Re: Moorebank Intermodal Precinct West – Concept Plan and Stage 1 (SSD-5066-Mod-2), and Stage 2 (SSD-7709-Mod-1)

Liverpool City Council (LCC) has received a request to comment on two separate modification applications relating to the Moorebank Intermodal West Precinct (MPW). The applicant SIMTA (as Qube Holdings Limited) has submitted this modification request to facilitate the construction of two Woolworths distribution and logistics centres within MPW.

2 PRECINCT PLAN - SSD 5066 MOD 2
- PROPOSED SCALE 1:5000 @ AD

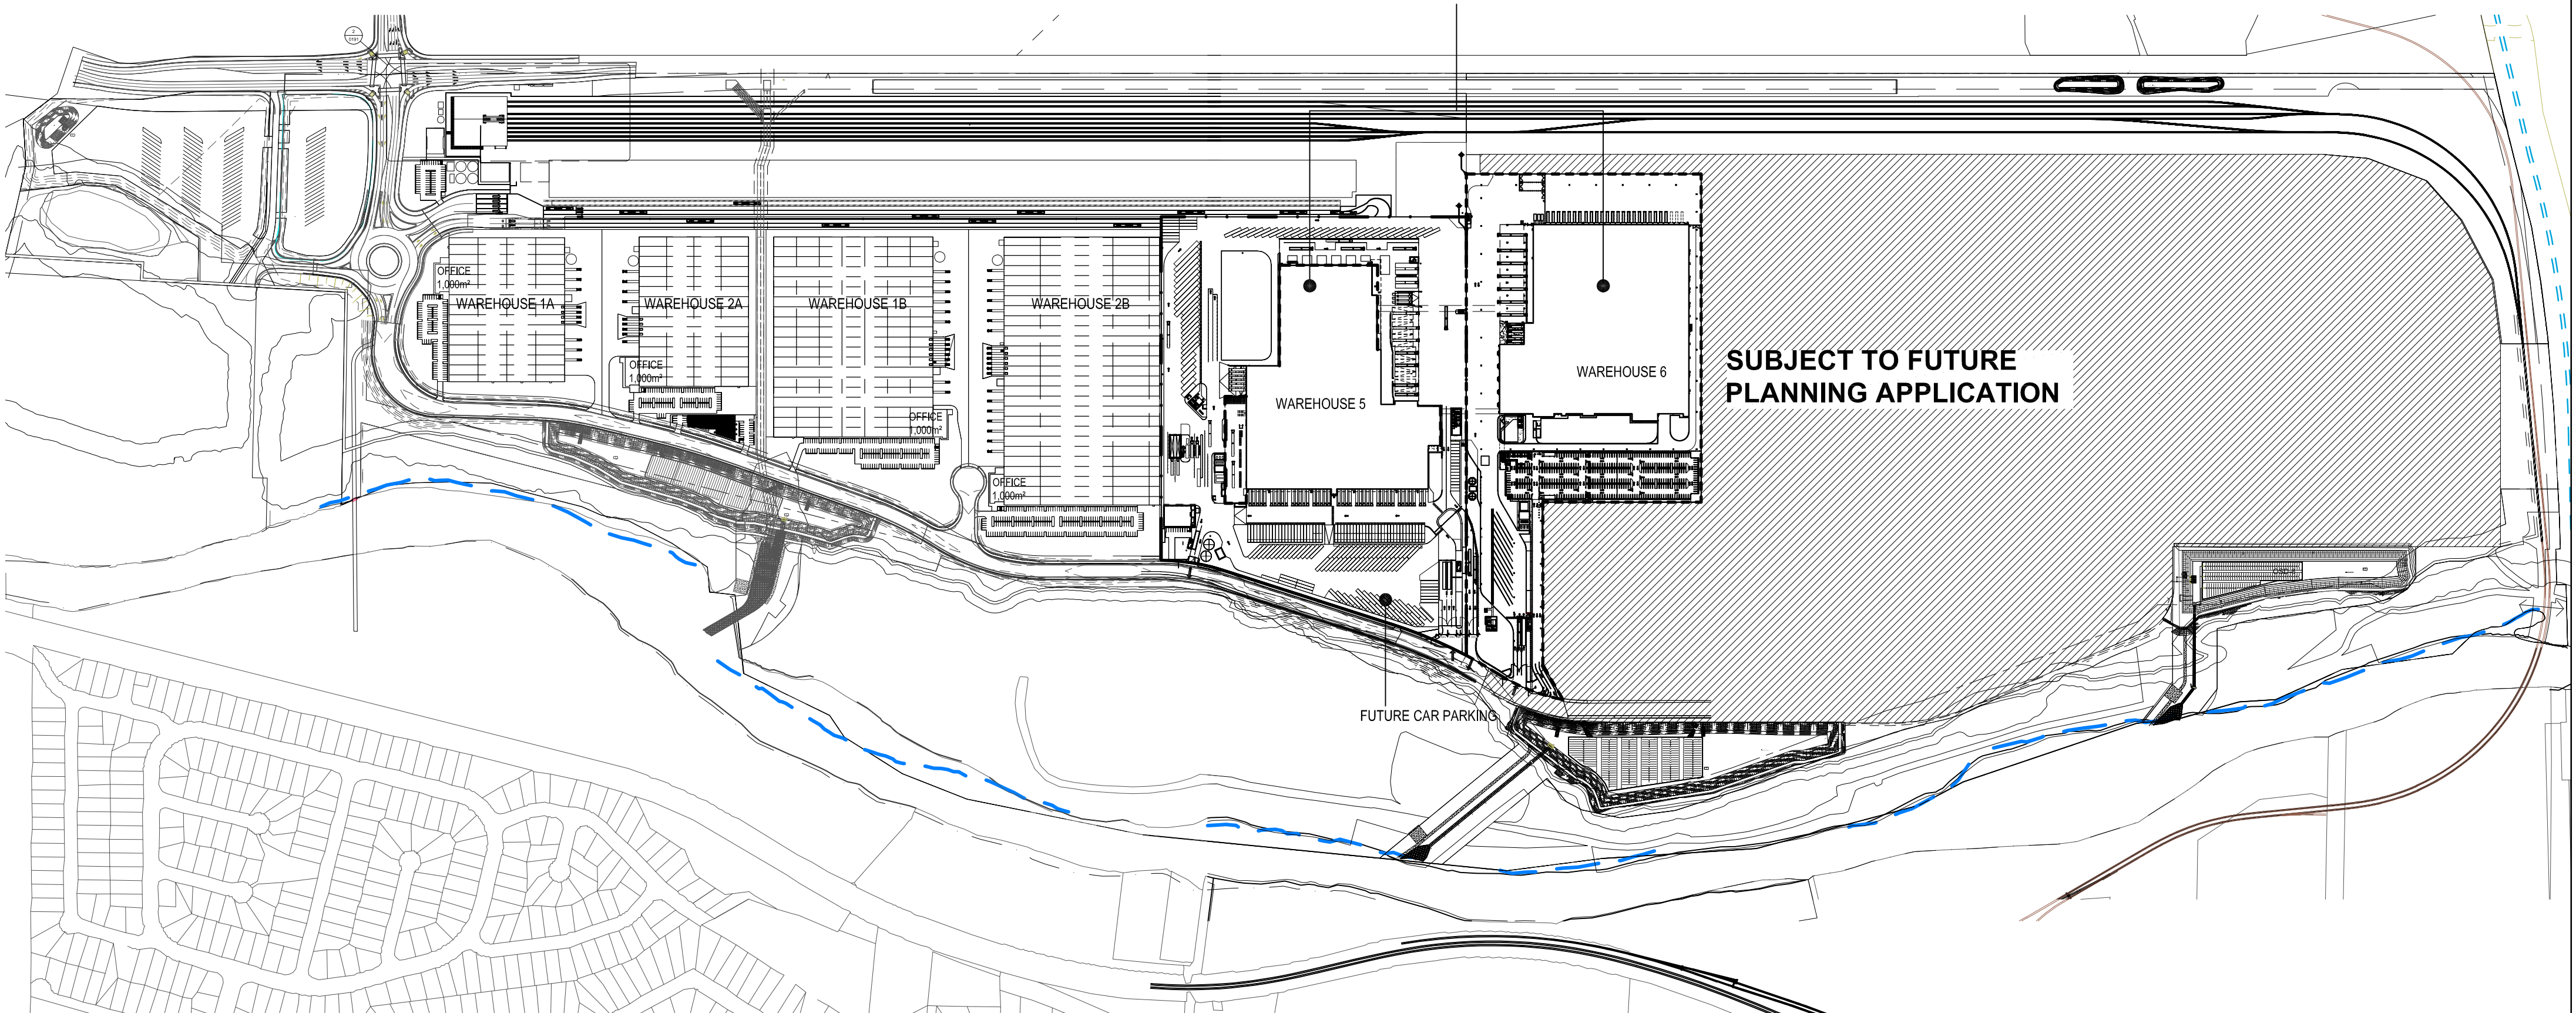
- **MPW Concept Plan and Stage 1 (SSD 5066 MOD 2)** – Adjust the southern operational boundary of the MPW Stage 2 warehouse area and amend the maximum building height established across warehouse areas 5 and 6 from approximately 21m up to and including 45m; and
- **MPW Stage 2 (SSD 7709 MOD 1)** – Adjust the southern operational boundary of the MPW Stage 2 warehouse area and amend the maximum building height established across warehouse areas 5 and 6 from approximately 21m up to and including 45m. Amendments are also sought to increase operational noise criteria and to allow for the storage of Dangerous Goods on-site at warehouse areas 5 and 6.

As stated within the *Clause 4.6 Variation – Height of Buildings (Clause 4.3)* prepared by Willowtree Planning, "the proposed modifications would result in an exceedance of the 21 m building height control under LLEP2008 by approximately 24 m (or by 114.29%)." Council has concerns regarding the visual impacts of the development, summarised below:

- The visual impacts of the proposed warehouses seem significant from certain vantage points in Casula including the loss of scenic views; and

- Mitigation measures cannot be provided that would enable the scenic views of properties in Casula to be retained.
